Application Reference: 2025/0246

Site Address: 1 Round Hill, Darton, Barnsley, S75 5QJ

Introduction:

This application seeks full planning permission for a 1st floor front extension (above integrated garage) to dwelling. This would be creating additional space for the second bedroom and space for an en-suit. The applicant would also like a window to the side elevation.

PROPOSED FIRST FLOOR PLAN

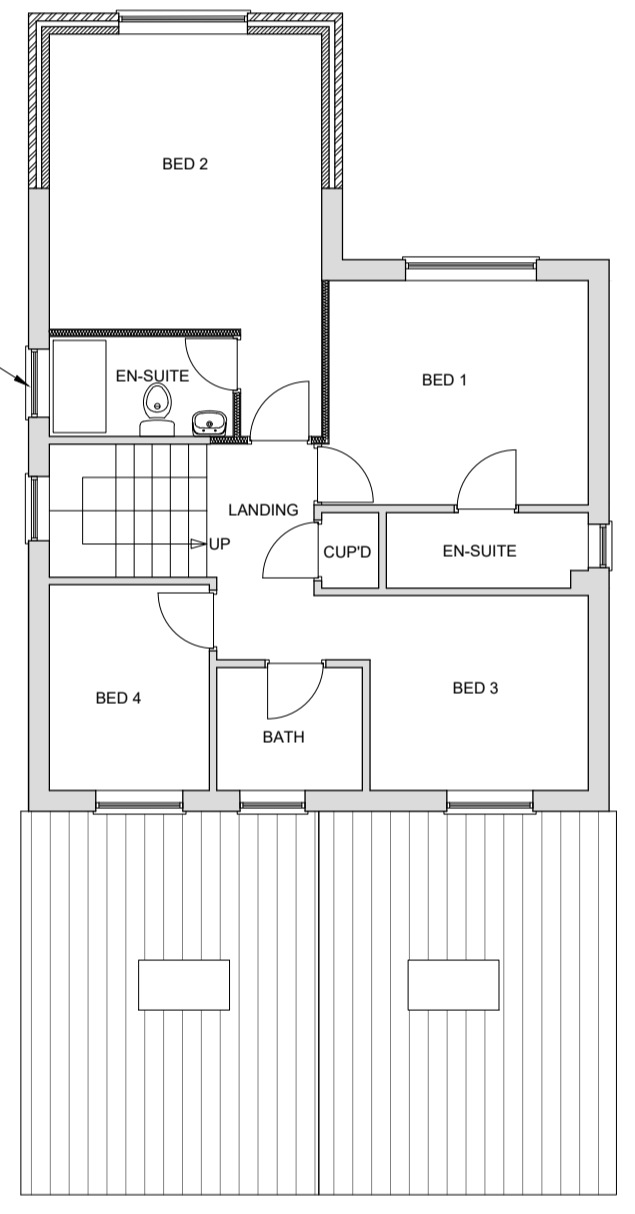
The applicant is proposing the erection of a 1st floor front extension (above integrated garage). This would provide additional space for the second bedroom and space for an en-suit. The applicant is also proposing to add an additional window to the side of the property this would provide light and ventilation to the en-suite. The window would also be obscurely glazed. The development would not move the building line forward but rather would be on top of the existing garage. The property is stepped back from its neighbour and as such the development would still be behind the neighbour.

PROPOSED FRONT ELEVATION

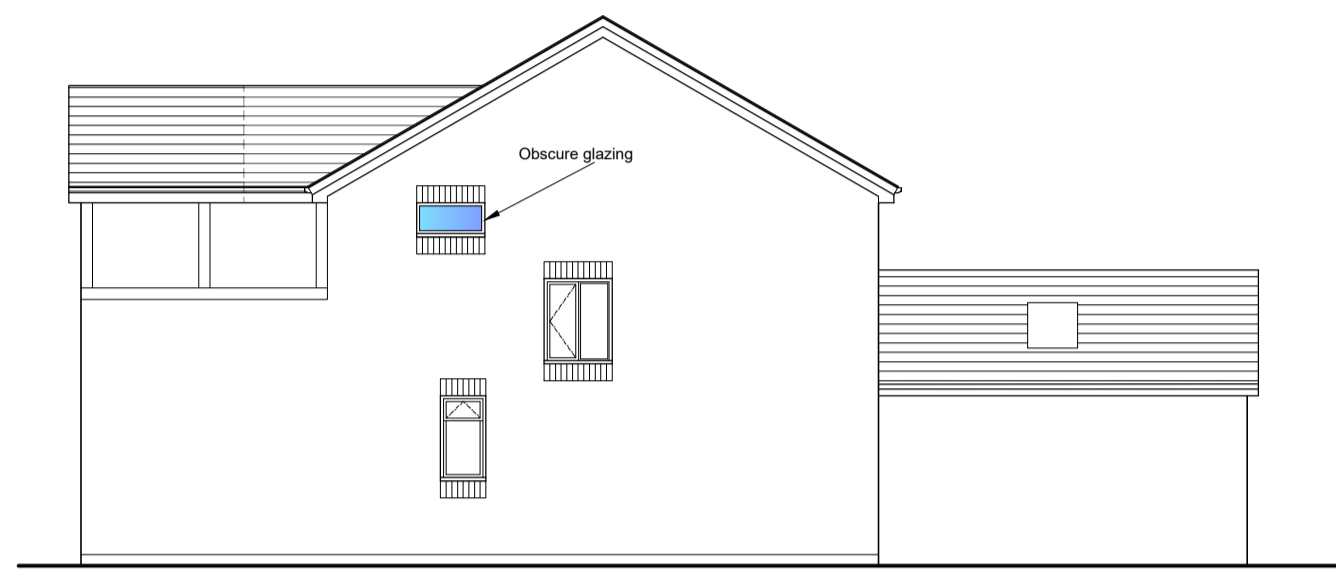
The scale and design of the extension would be considered to be acceptable and would not be out of character for the area. The applicant has stated that the same materials would be used externally to match the existing house. The scheme would integrate with the current design of the house and would not harm the character of the area. There are examples of similar extensions in the area with extensions above garages and as such would not stand out as an anomaly.

PROPOSED SIDE ELEVATION

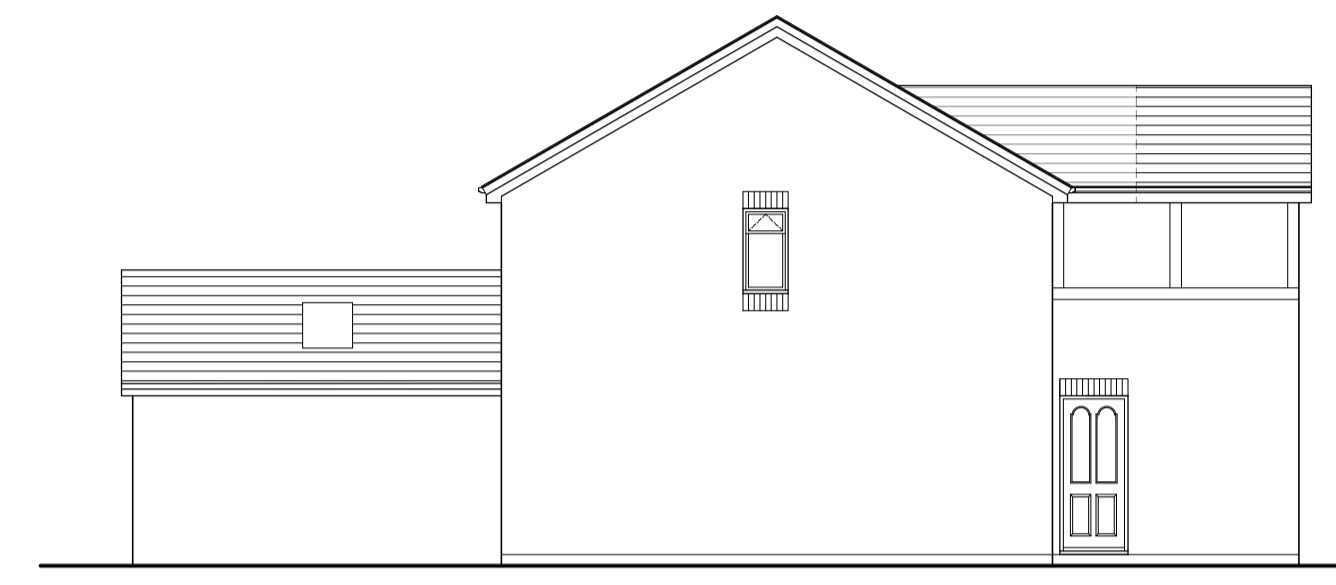
The proposal would not project any further than the current attached garage which is at the front of the property. The applicant has also proposed an obscurely glazed window to the side of the property for the use of the en-suite. The scheme would not result in overlooking and would not impact the 45-degree code. Therefore, the neighbouring amenity would be protected.
